Department of Industry

Concrush Resource Recovery Facility Expansion (SSD 8753) Response to Submissions

Figure 6 | Conceptual Surface Water Management System

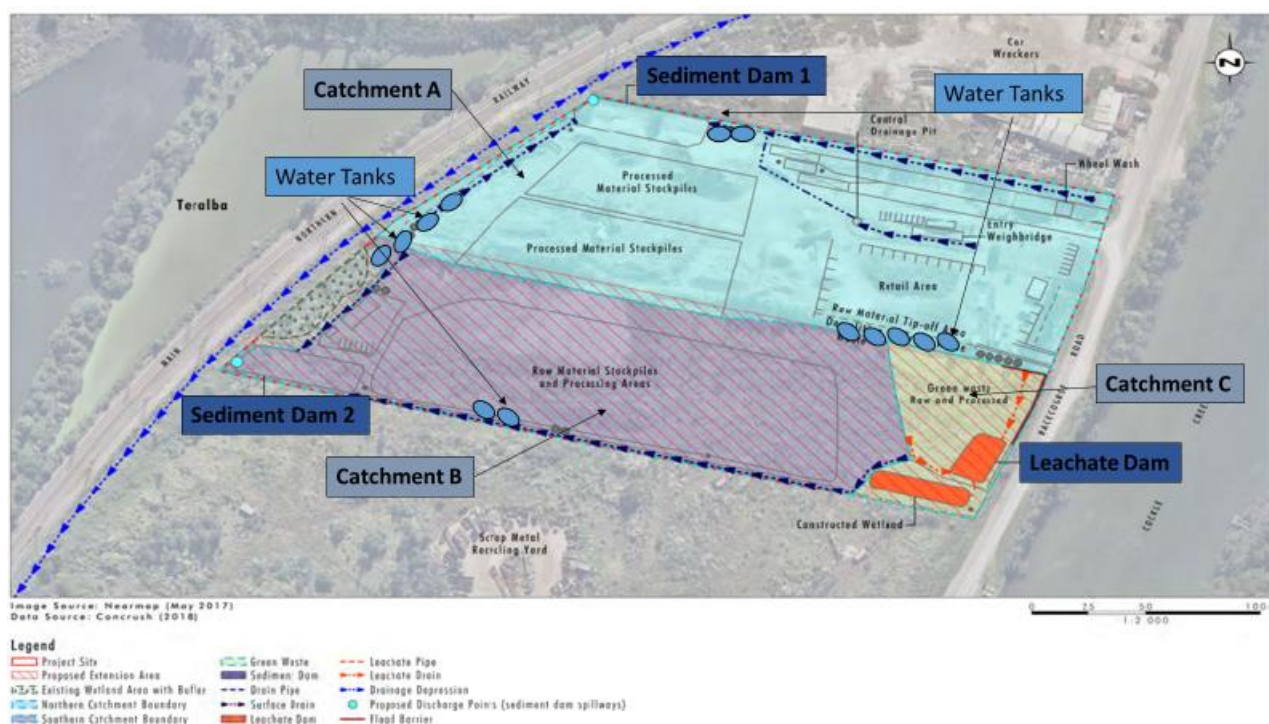
- A test hole should be constructed at both the leachate pond and artificial wetland to determine water table depth. The results should be compared against the intended excavation depths of the leachate pond and artificial wetland. If excavation depths are to be within 0.5m of the measured water table, an Acid Sulfate Soil Management Plan should be developed prior to excavation works.
